# KITTITAS COUNTY

## DEPARTMENT OF PUBLIC WORKS

**TO:** All Staff  
**FROM:** Justin Turnbull, Kittitas County Public Works Surveyor  
**DATE:** October 27, 2022  
**SUBJECT:** BL-22-00020 Schultz Survey Review

SCHULTZ PROPERTY

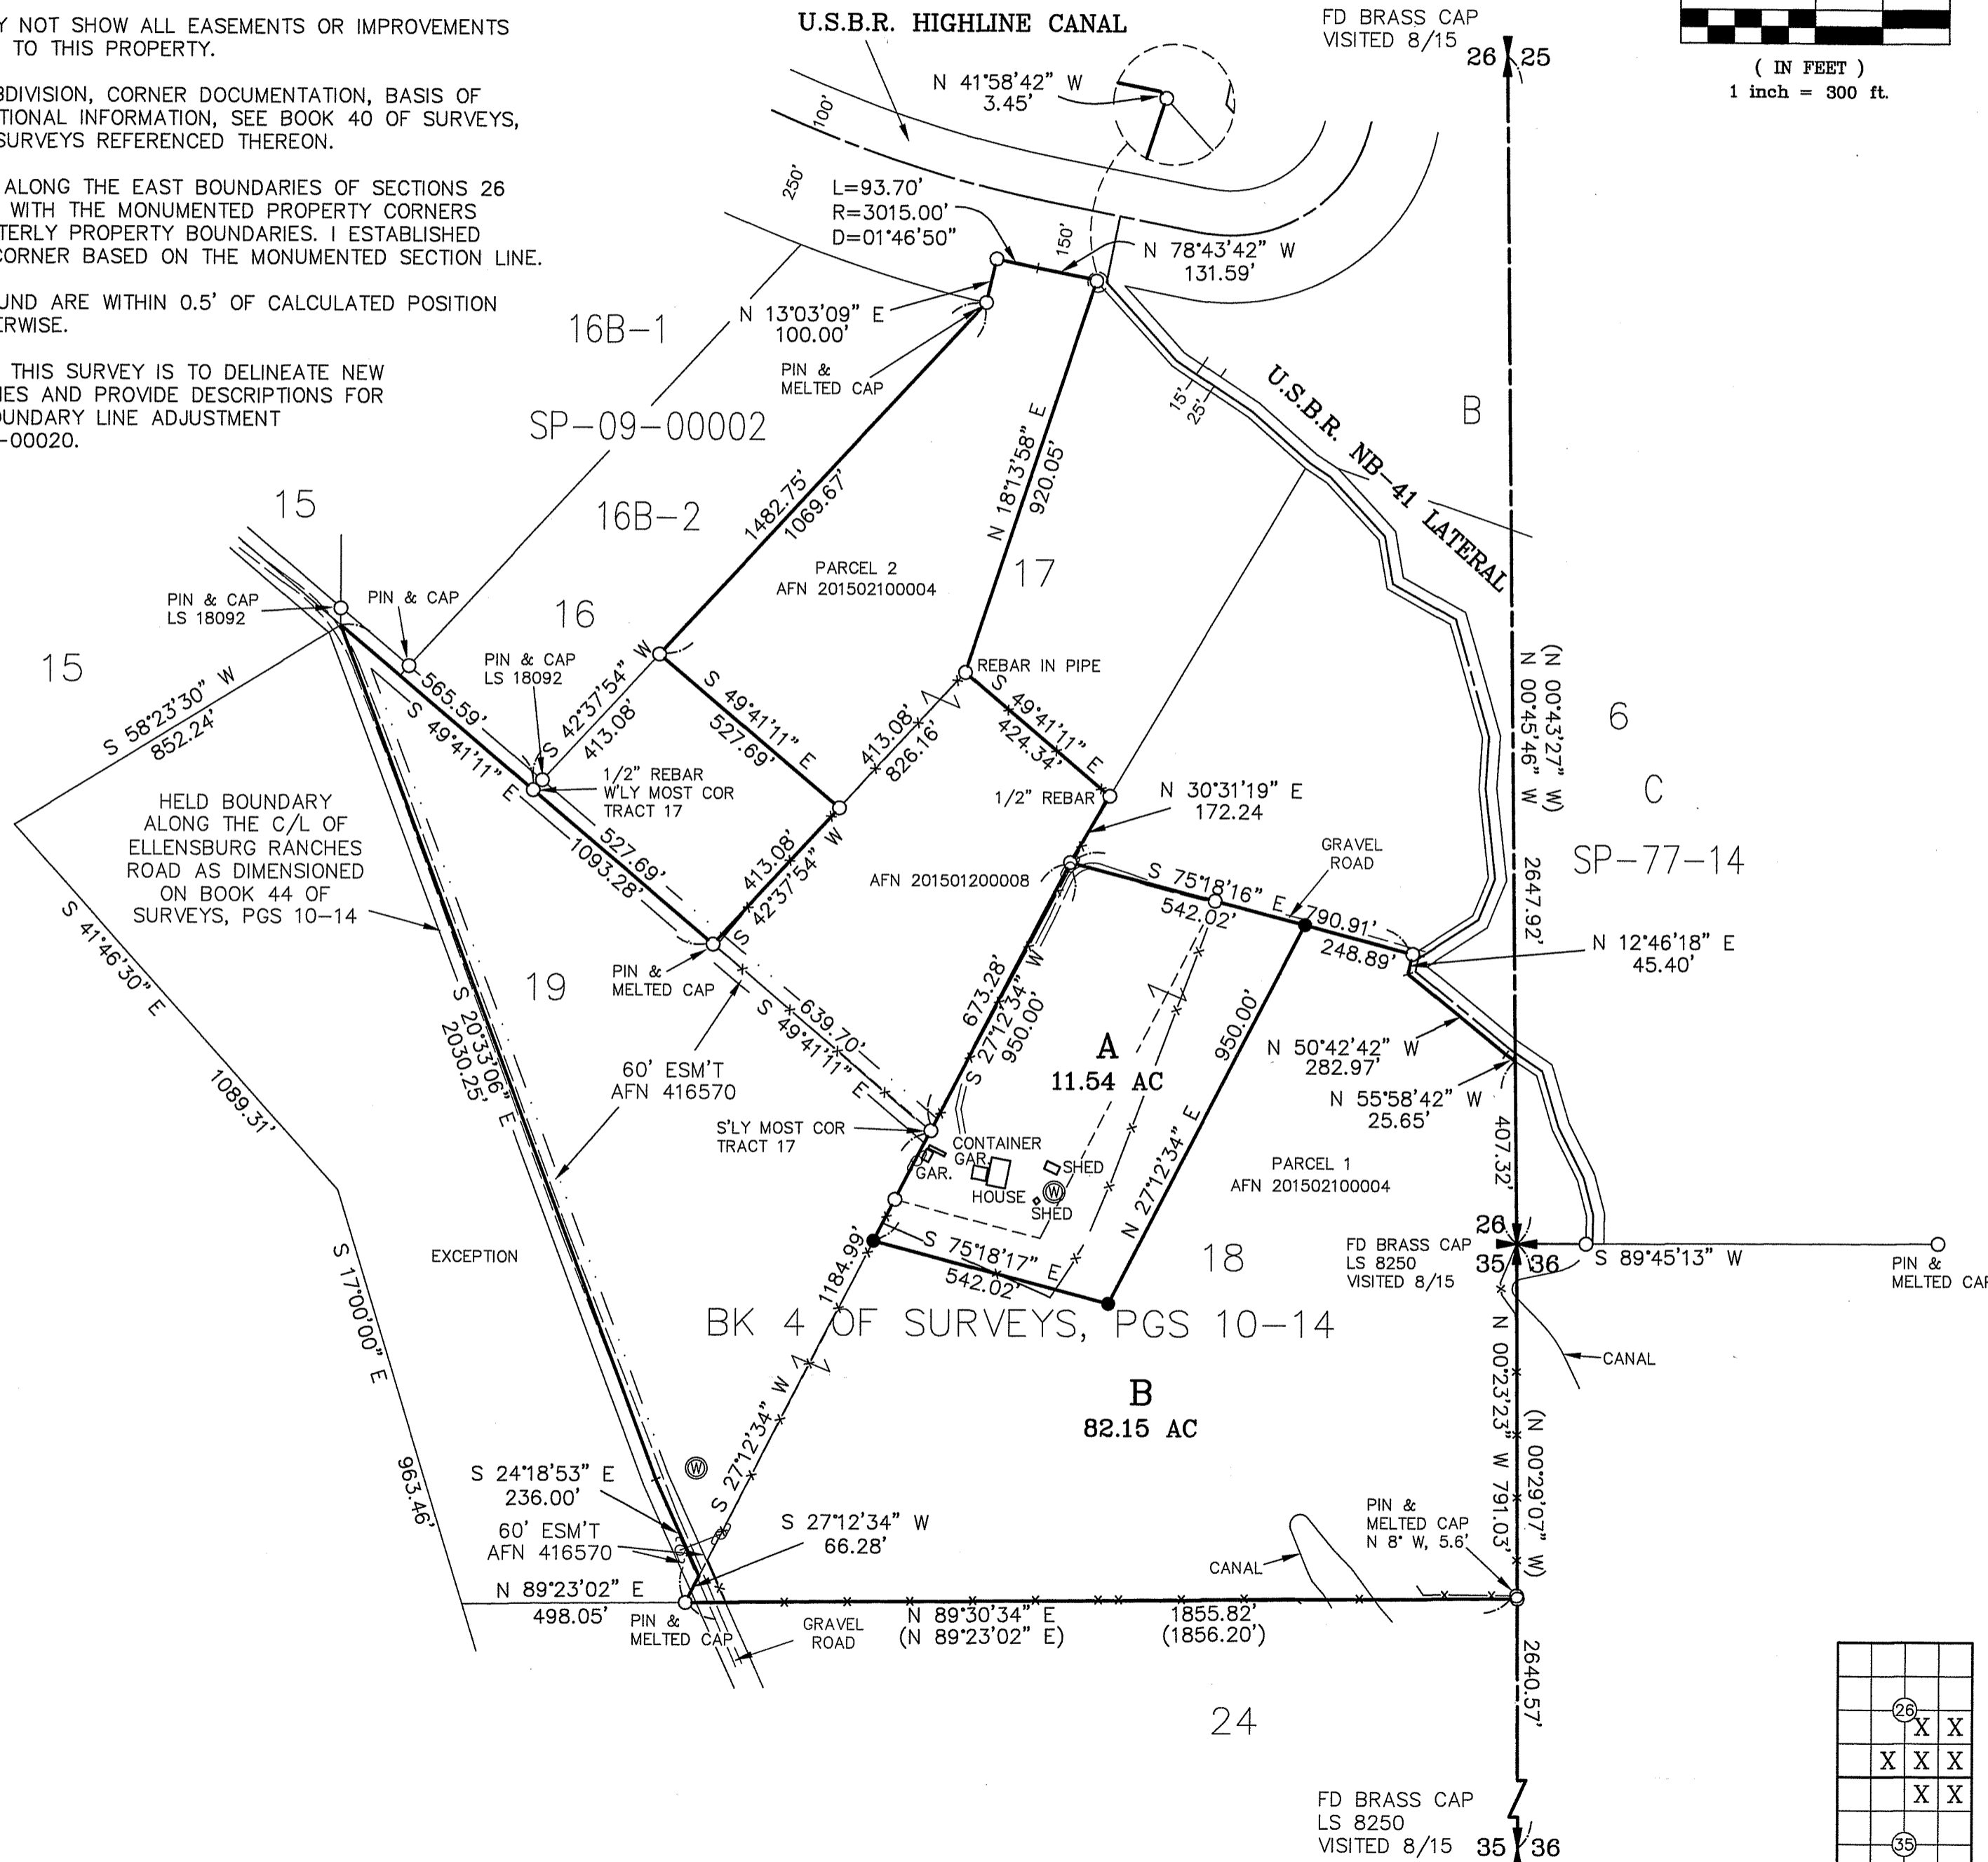
<b>SURVEY</b>	<ol style="list-style-type: none"><li>1. Identify "Previous Boundary" (or similar naming) prior to proposed BLA.</li><li>2. Identify the dashed line shown on Parcel A. (Lot line per Survey: 4-10).</li><li>3. Correct Typo for Label of Ellensburg Ranches Road (Book 4, Not Book 44).</li><li>4. There is a body of water located near the Westernmost point of Lot A. If this is a permanent pond, it should be shown and labeled. If it does not exist year-round, this is not required to be shown.</li><li>5. Note 4 appears to be copied from record. Please modify for clarity. I respectfully suggest the following changes, "The monuments along the East boundaries of Sections 26 and 35 do not fit the monumented property corners found on the Westerly property boundaries <u>OF SURVEY BK. 4, PG. 29. I PREVIOUSLY</u> established the SE property corner based on the monumented Section line".</li><li>6. It is unclear from record if the portion of land within Section 25 lying West of the USBR Lateral is a portion of Lot 6 or Lot 18 (Survey Bk:4, Pg. 10). It appears to be NOT included as a part of Lot 6 per subsequent Short Plat Bk: A, Pg. 29. If this portion has not been resolved as part of applicants research, at minimum it should be labeled as a possible gap in ownership.</li></ol>
